Subject: RE: Amended site layout - the Lillies Caravan park site, Yapton Road, Barnham

Subject: RE: Amended site layout - the Lillies Caravan park site, Yapton Road, Barnham

Flat Block A
Floor Plans & Elevations
Plots 19-24

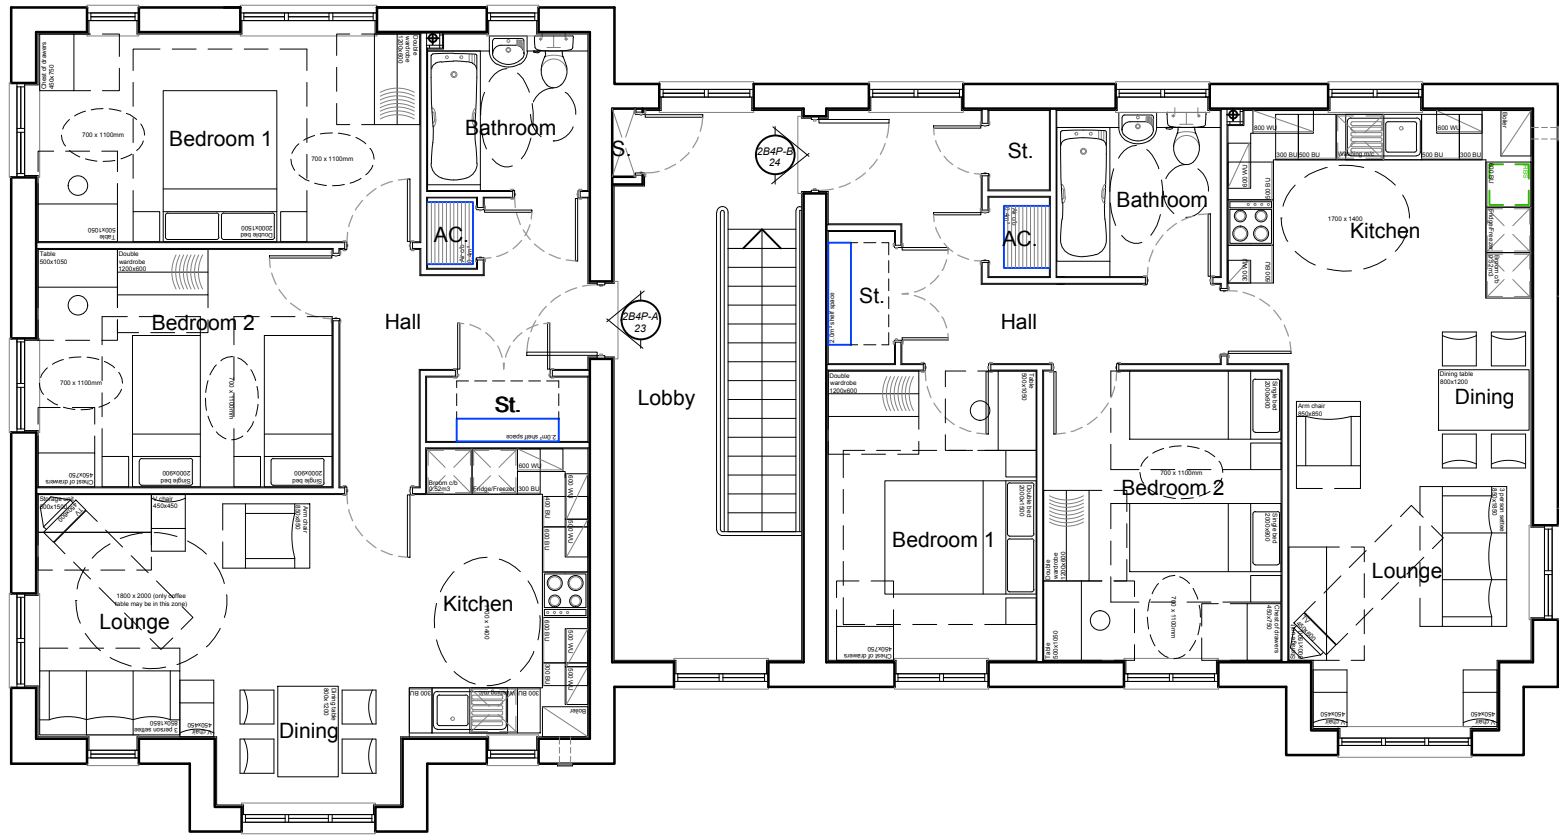
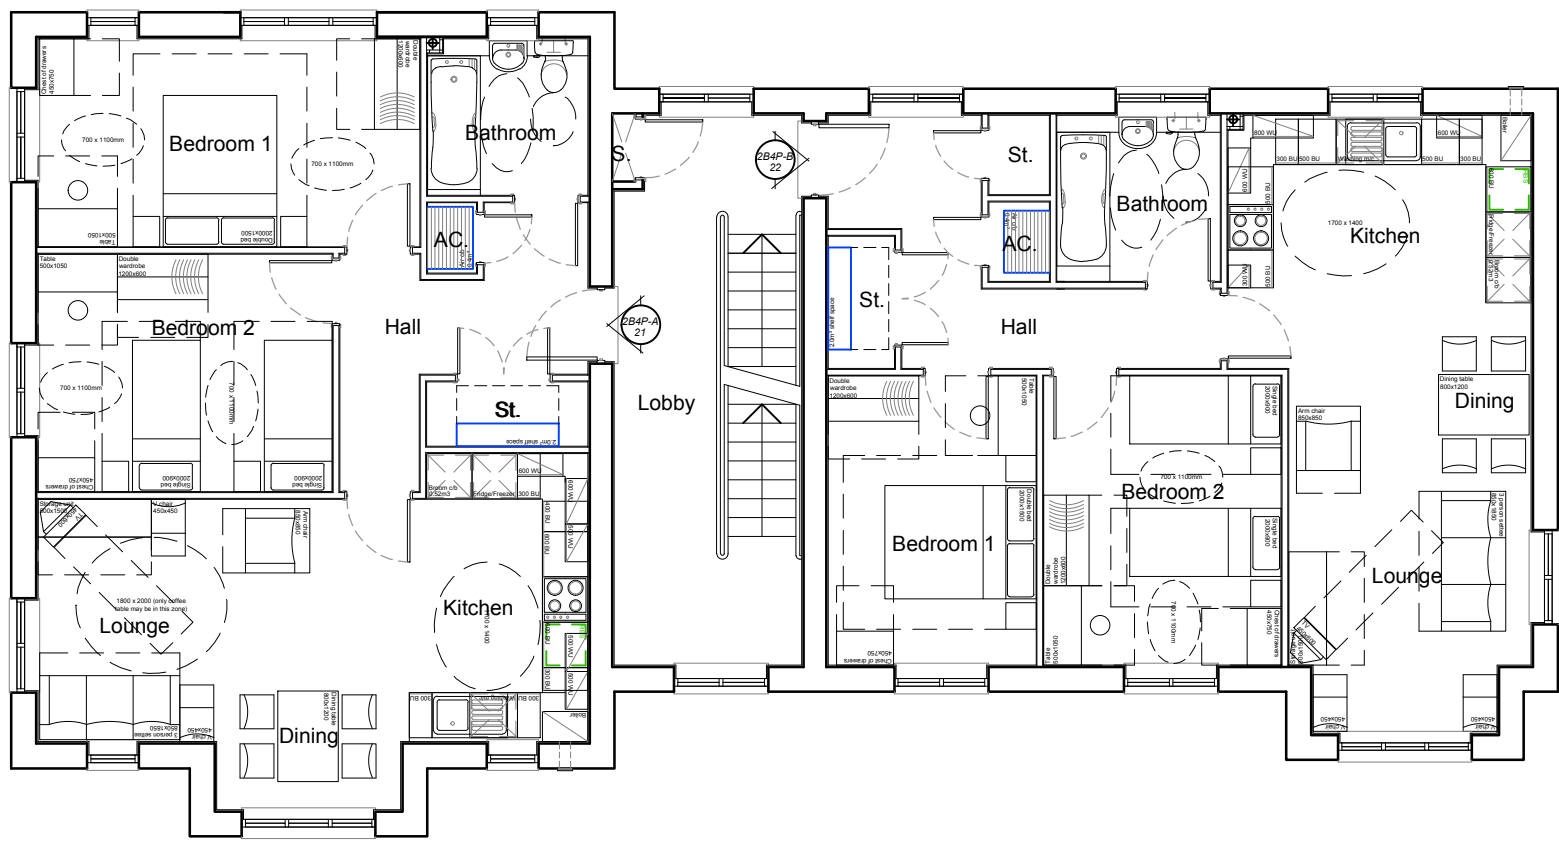
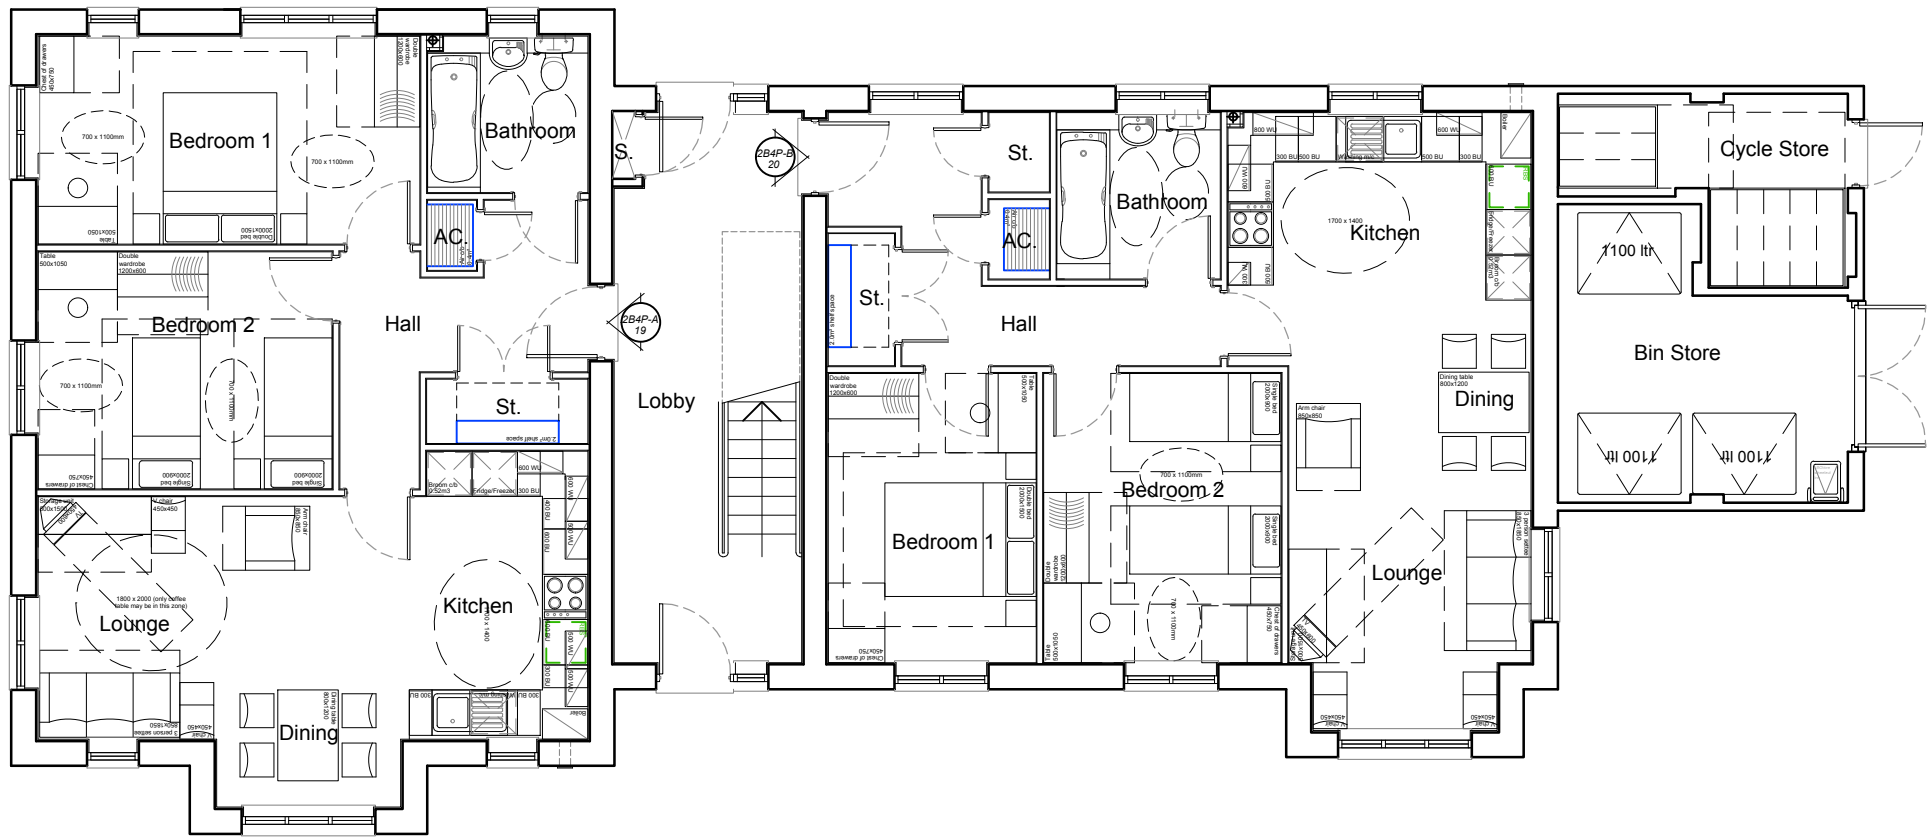
The now indicated attenuation basin to the centre of the POS is also of concern and would require clarification of whether this will be a standing water body? And what element of the year this will be the case? This area only depletes the POS as it would then not be classed as usable POS? and my concern also is regarding proximity of this in relation to Flat Block A 19-24 which should be raised and addressed.

The flat block is deemed ok location wise to the basin, no issues from the ADC Drainage consultant.
